State of Washington
DEPARTMENT OF FISH AND WILDLIFE

May 23, 2017

RE: WDFW comments on PD-16-00001 and LP-17-00004 MDJ Rezone and Long Plat near Currier Creek

N 54°53'30" E
19.52'
SW CORNER
N 1/2 SW 1/4
PER BK 30
OF SURVEYS,
PG 12

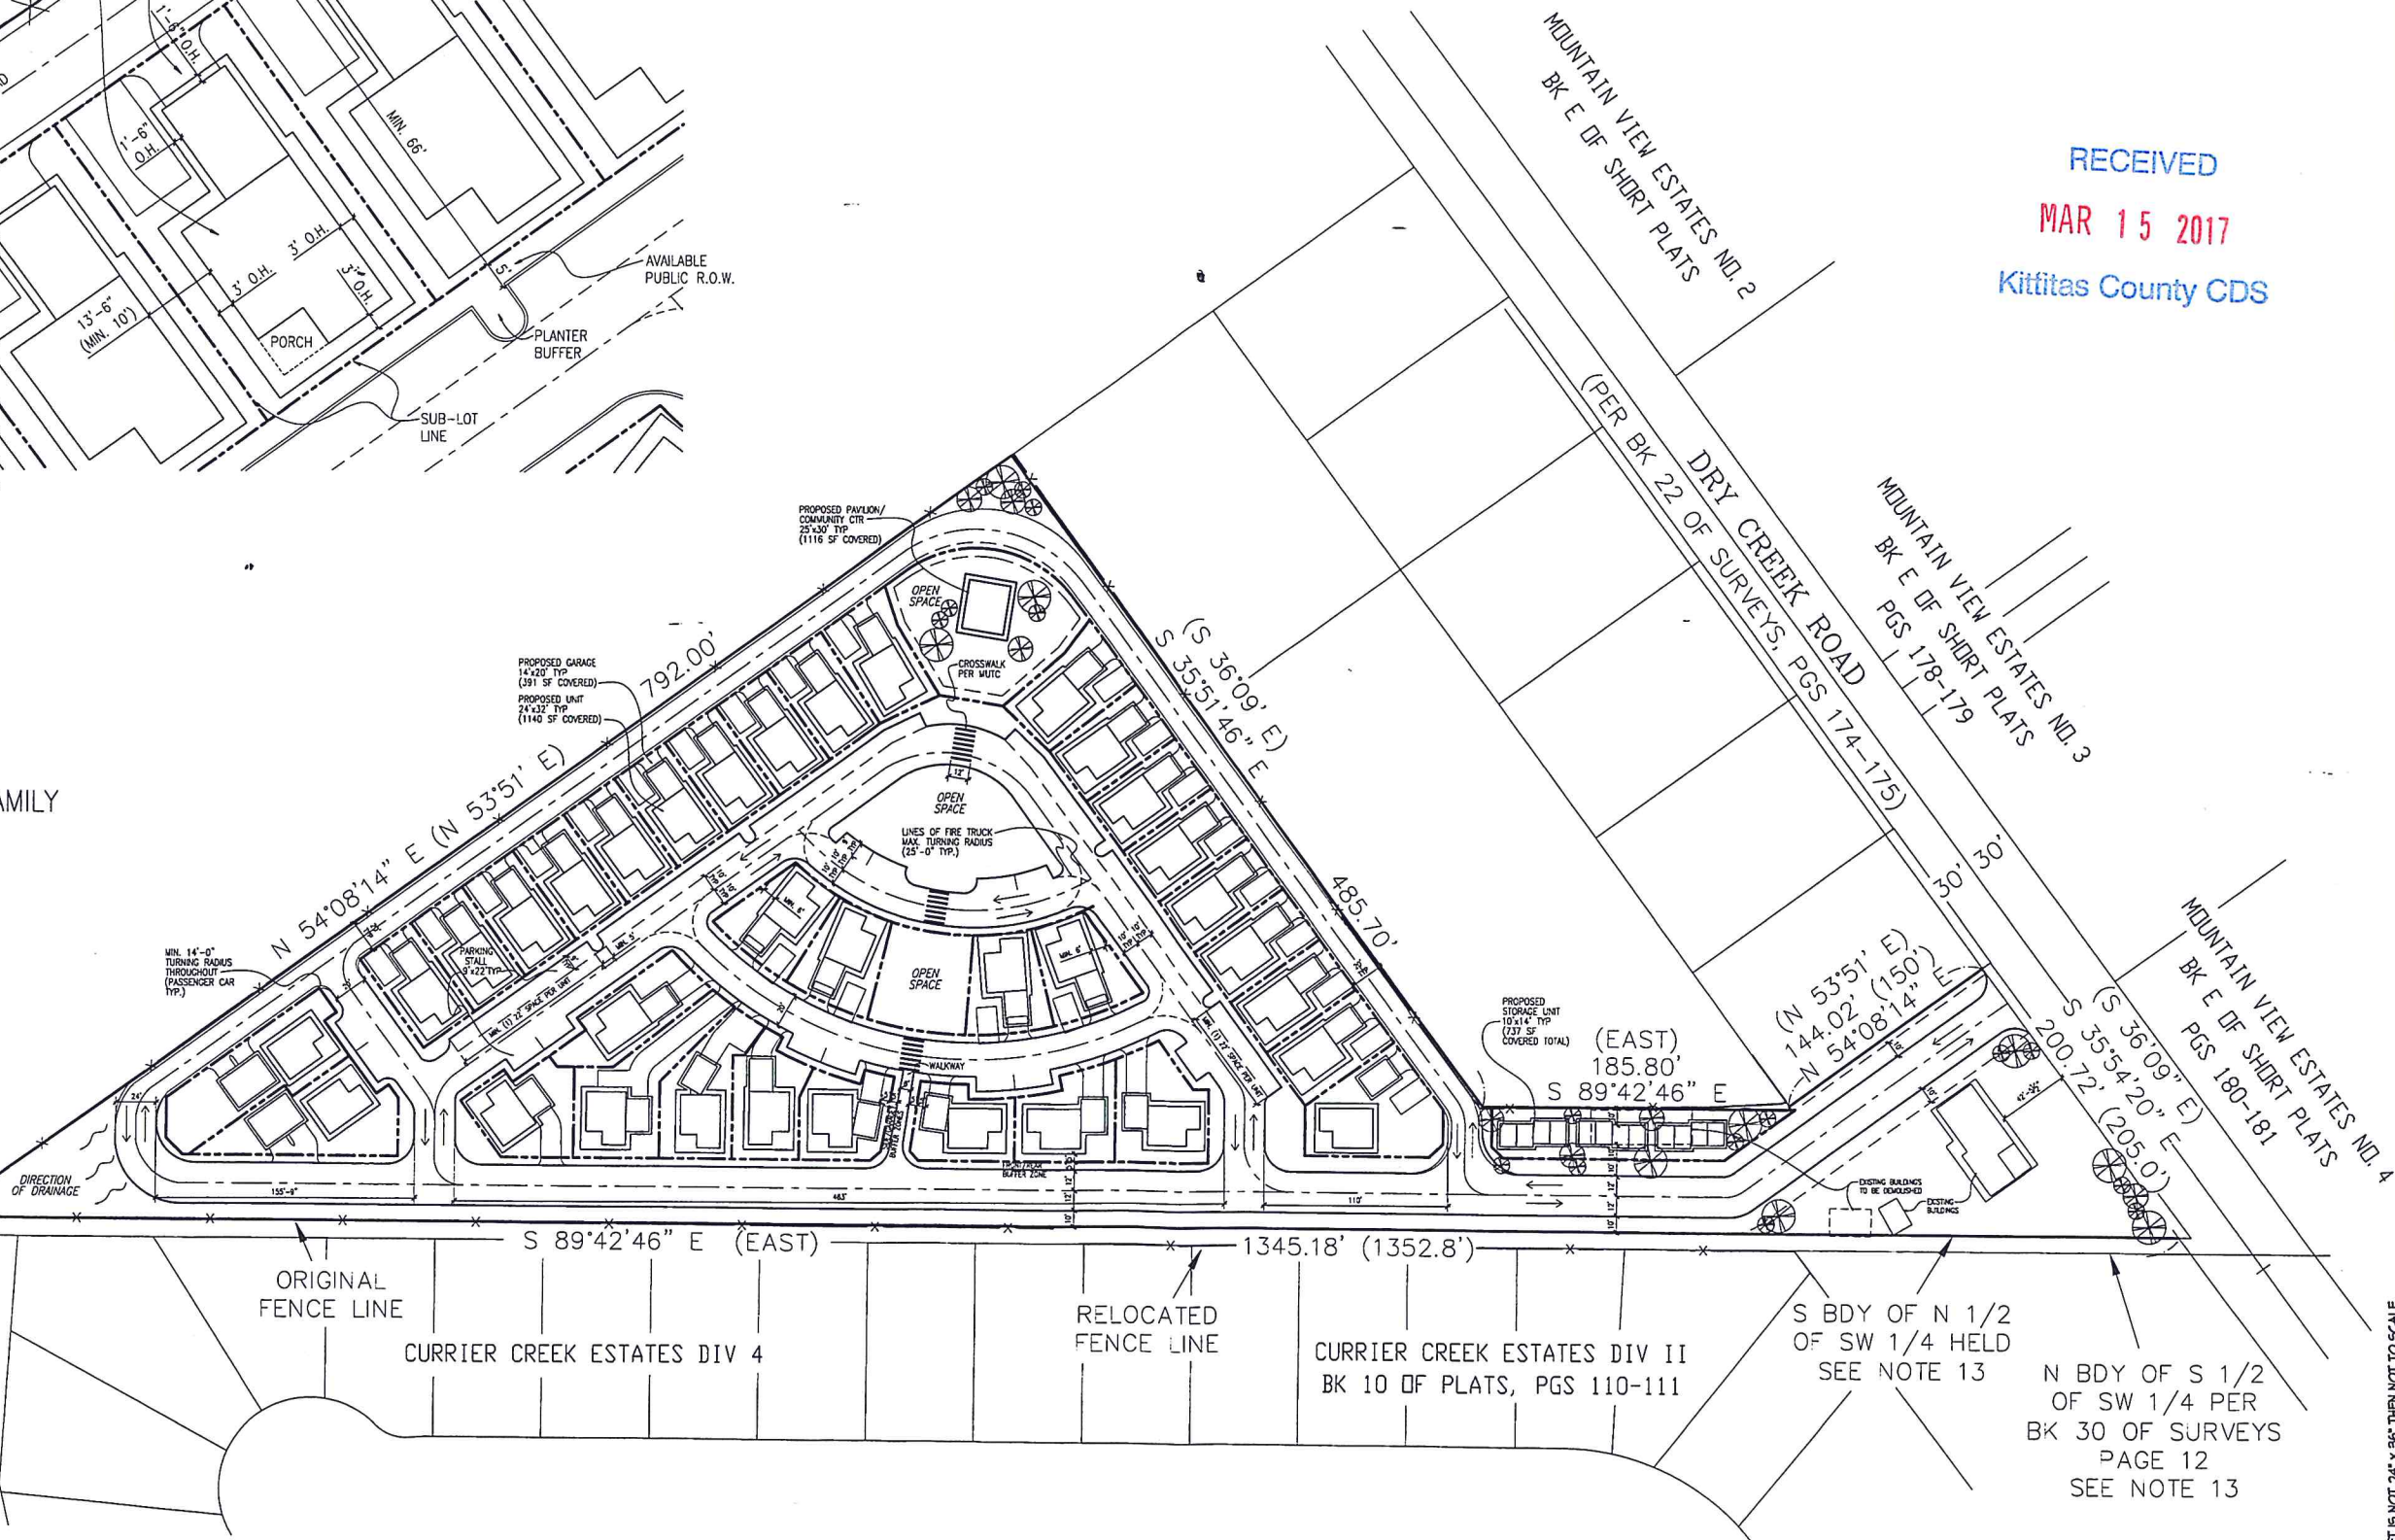
With the information provided to us for review, WDFW believes the proposed development will likely result in the new homes being flooded and increased flood risks to surrounding properties due to reduced floodplain capacity and impacts to wetland habitat. In light of the presence of surface water and potential for floodplain

impacts, an EIS may be warranted. In the very least, WDFW recommends delaying approval both the rezone (PD-16-00001) and long plat (LP-17-00004) until the following reviews and studies have been completed:

- Provide the wetland report referenced in the SEPA documents for public review and comment.
- Require a detailed study to determine whether or not the proposed development will increase flood risks to surrounding property owners and if the proposed new structures will be flooded. This study should also detail how flows (quantities and velocities) may be altered as they relate to Currier Creek and the fish and wildlife habitat associated with it.
- Require a detailed study to determine if there is a loss of floodplain conveyance and storage. Provide appropriate mitigation if warranted.
- If warranted based upon information from the studies mentioned above, reduce the lot density to allow for more floodplain storage. This may include enhancing wetland habitat within the proposed open space areas.

This is the proposed
 rezone and long plat for
 MDJ-Cottage
 Grove/Currier Heights.
 Currier Creek Estates is
 located immediately
 south of this
 development and
 homes along Creeks
 Edge Way already
 experience flooding.
